**REQUEST FOR COMMENT ON THE MODIFICATION APPLICATION AND REPORT FOR THE
MODIFICATION 9 LONGWALL REORIENTATION (SSD-5144)**

Thank you for the opportunity to provide comment on the proposed modification to the Mandalong Southern Extension Project involving the reorientation of the longwall mining panels to account for recently discovered geological conditions and the reduction in the number of planned longwall panels from eight to five.

EKG
D14014264
Your Reference: SSD5144 MOD 9

MANDALONG LONGWALL REORIENTATION - MODIFICATION 9

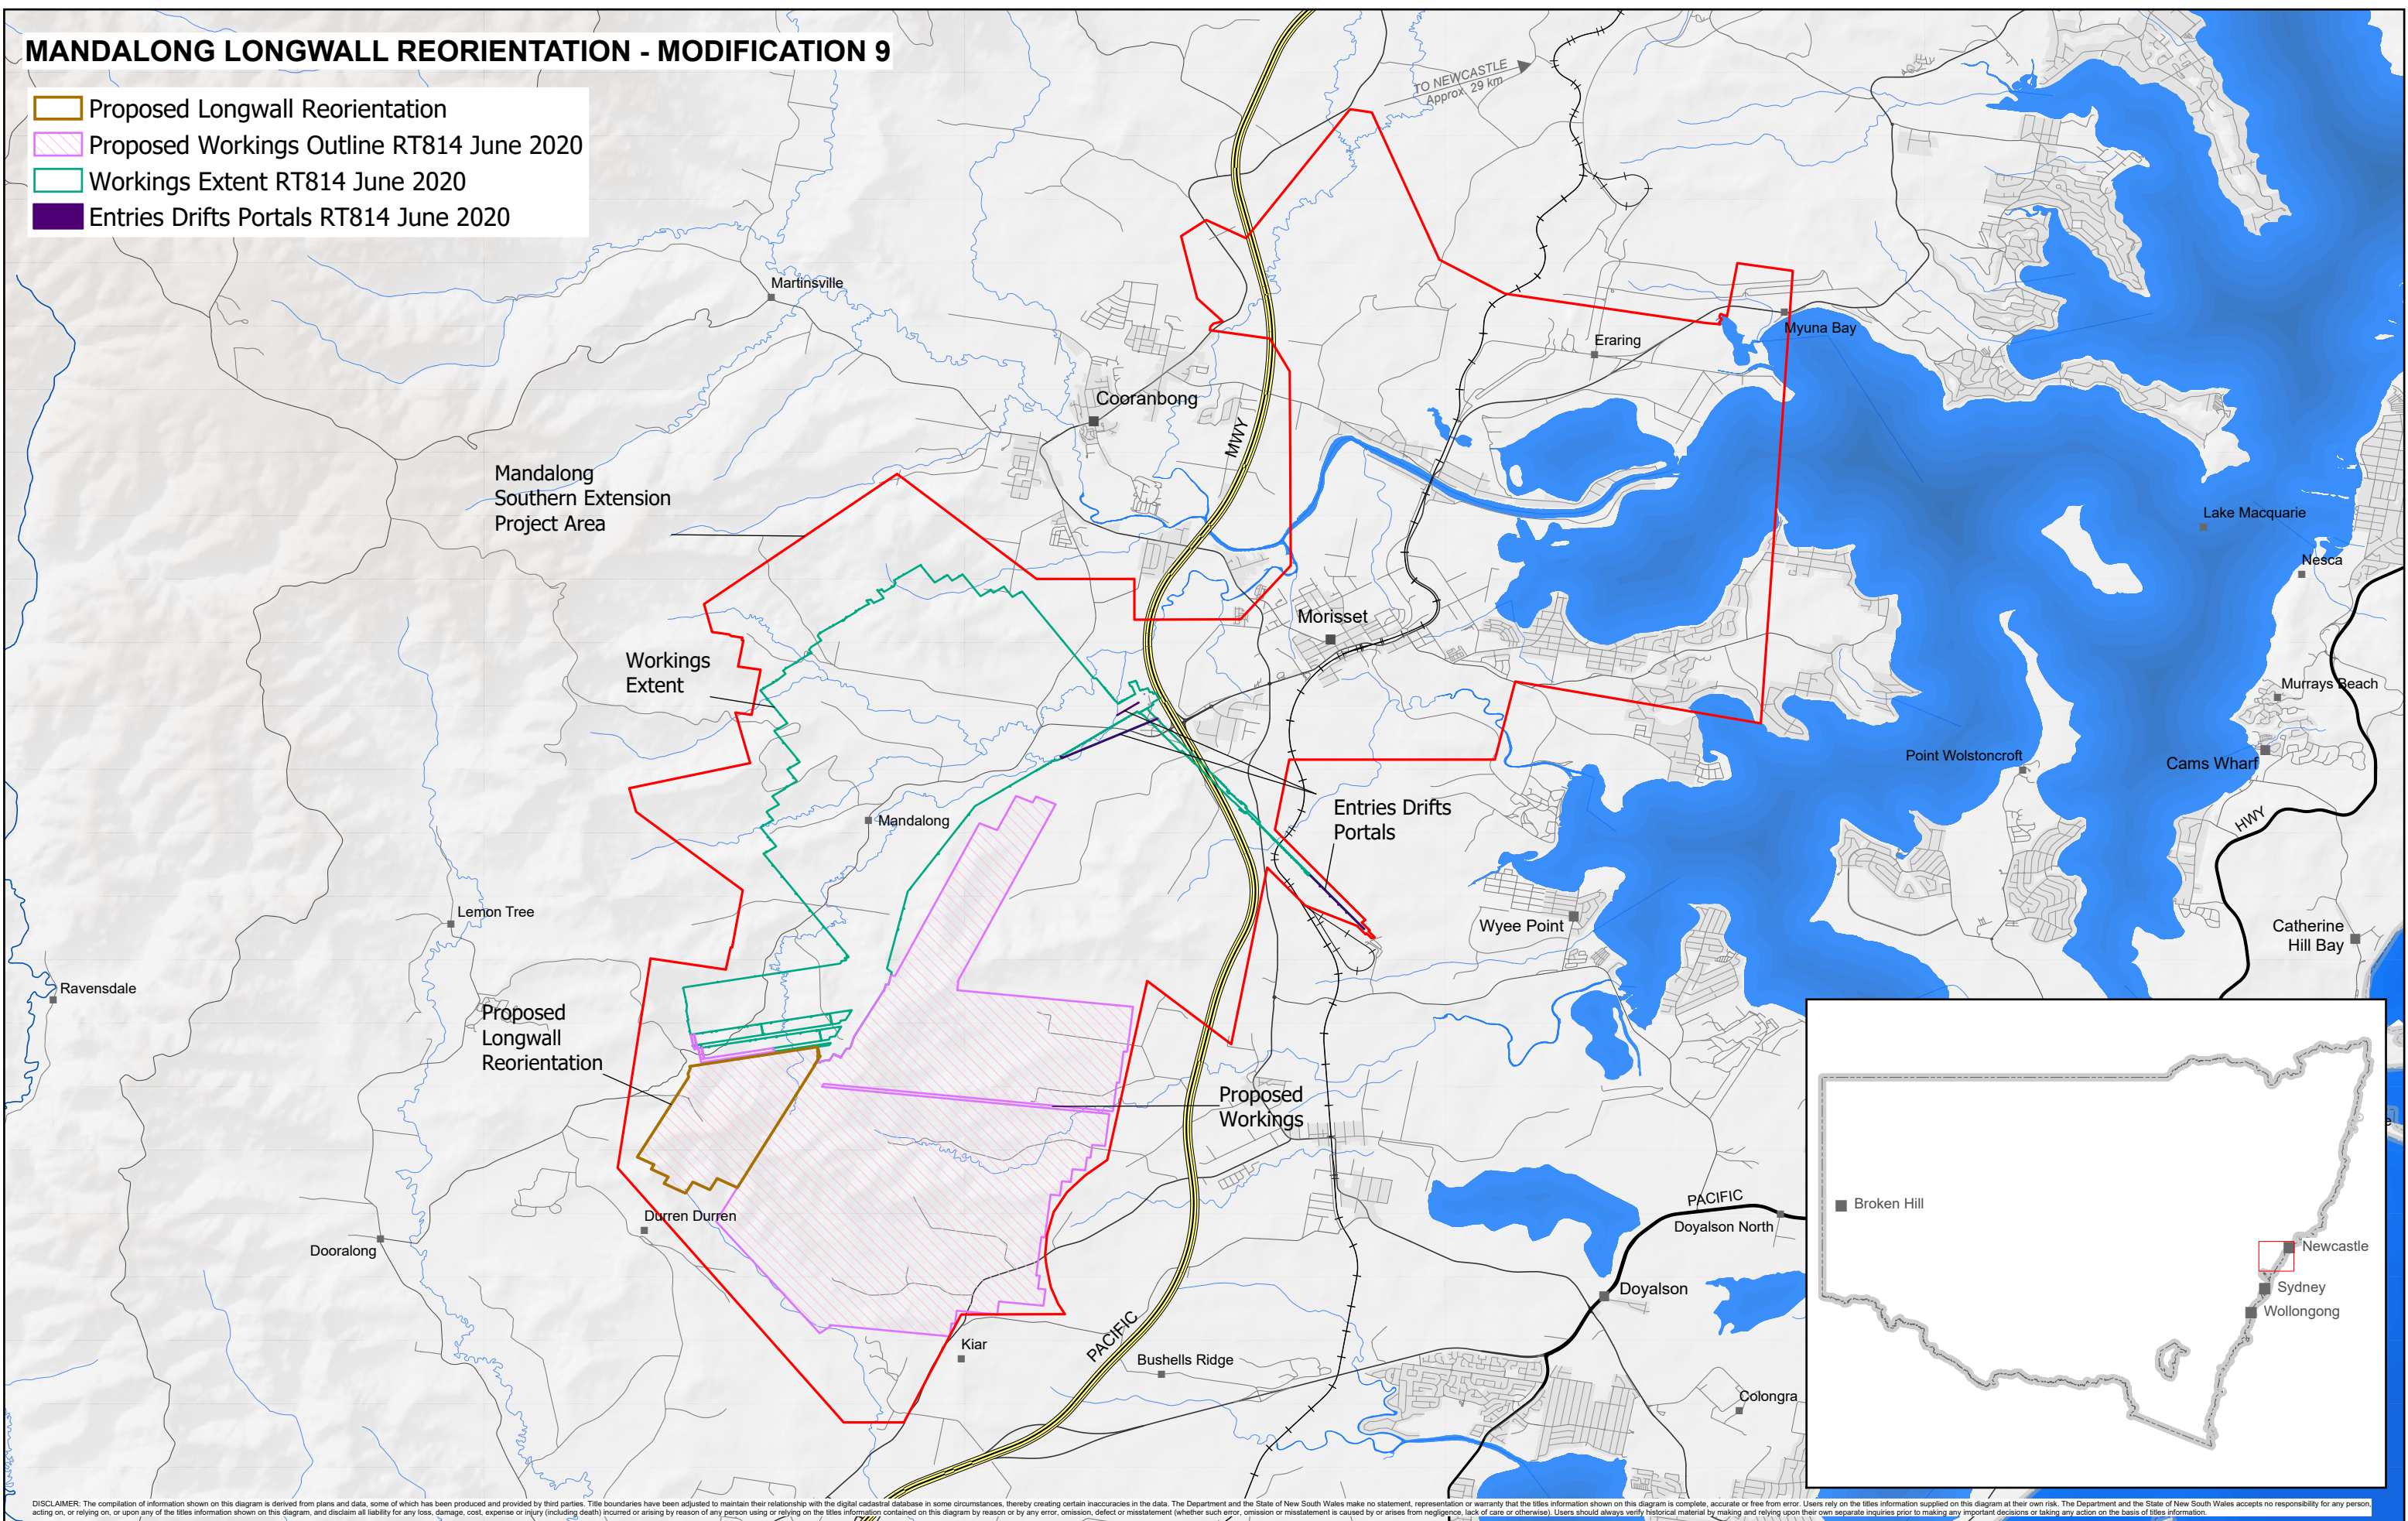
5. Figure 3.1 of the modification report shows that the “Main heading” running north-south is proposed to be straightened and the bend at the southern end which is towards Buttonderry Waste Management Facility extends along Buttonderry Creek for a longer length and will end at the same point on the Buttonderry Waste Facility Boundary as indicated on the “original approved plans”. This could impact Buttonderry Waste Management Facility in the future, especially if longwall 54 is constructed as is shown on the plans.

Additionally, concern is still raised for longwall 54 and the “main heading” which is shown to be extending inside the Buttonderry Waste Management Facility boundary as part of the

approved mine plan (refer page 15 of EMM document and figure 1 below). Concern was raised by council in 2014 regarding the likely impacts that longwall 54 would have upon the Buttonderry Waste Management Facility and the impacts that Buttonderry Waste Management Facility may have upon longwall 54. It was council's understanding that Centennial reviewed council's comments at the time and agreed that longwall 54 would not proceed and would be removed from the plans. It is acknowledged this longwall is not the subject of the proposed modification, however, consideration should be given by Centennial for the relocation or removal of longwall 54 from within the Buttonderry Waste Management Facility boundary.
